RE: Response to Environmental Impact Statement for proposed Nihon University at No. 9 Church Street, Newcastle – ‘Newcastle Courthouse’, SHR No. 00796.

I refer to your email dated 20 May 2019 inviting comment from the Heritage Council on the Environmental Impact Statement currently on exhibition for the proposed Nihon University Newcastle Campus at 9 Church Newcastle. Part of this site (the 1892 Courthouse building) is currently listed on the State Heritage Register as ‘Newcastle Court House’, State Heritage Register No. 00796. The remainder of the site (the 1949 and 1966 buildings) is listed within ‘Newcastle Government House and Domain’, State Heritage Register No. 01841.

Planner										Nihon University Australia Newcastle Campus Project		Drawing No. A - 0
Conservation Plan										Scale 1/100	Rev 1

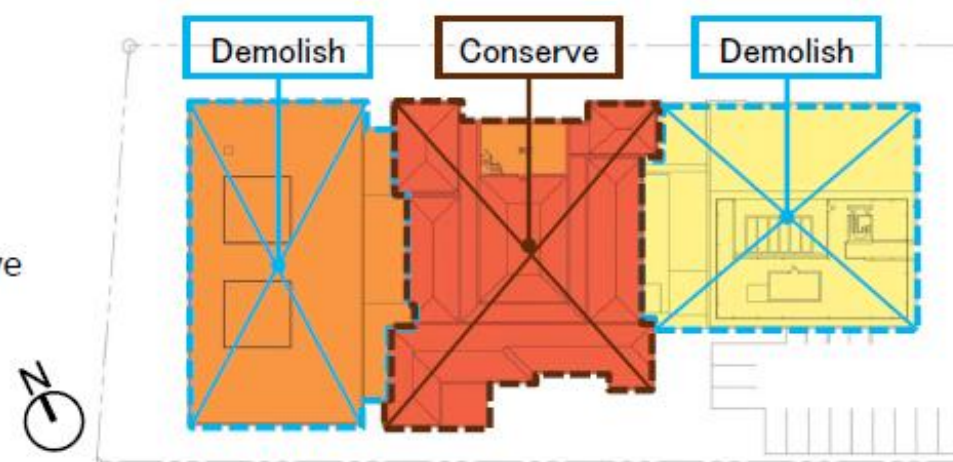
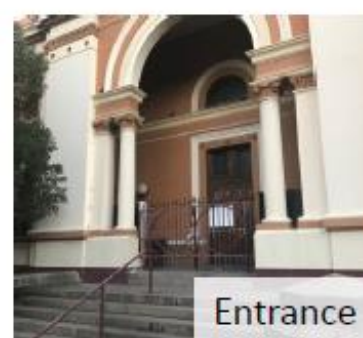
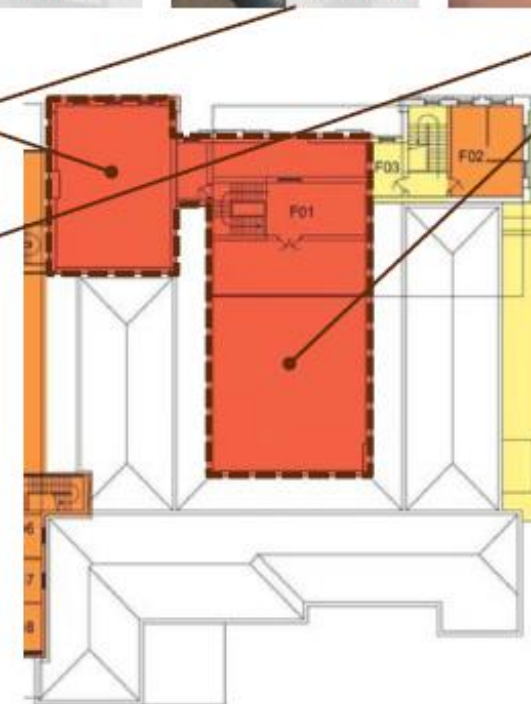
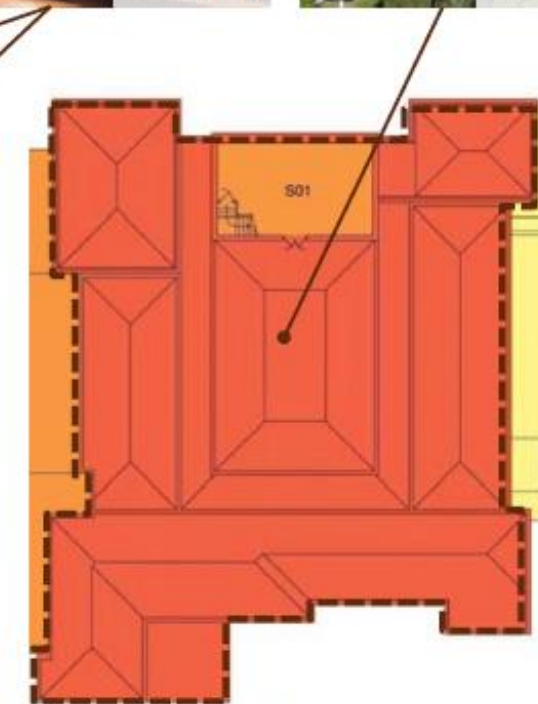
1. Based on the plans within the EIS documentation, some of the works within the 1892 Court house will involve physical impacts to areas and fabric graded as High Significance in the endorsed 2015 Tanner, Kibble & Denton CMP (such as in room G.06).
The approved conditions of approval should require that all impacts to areas and fabric of high significance be limited to those works required to make the building functional.
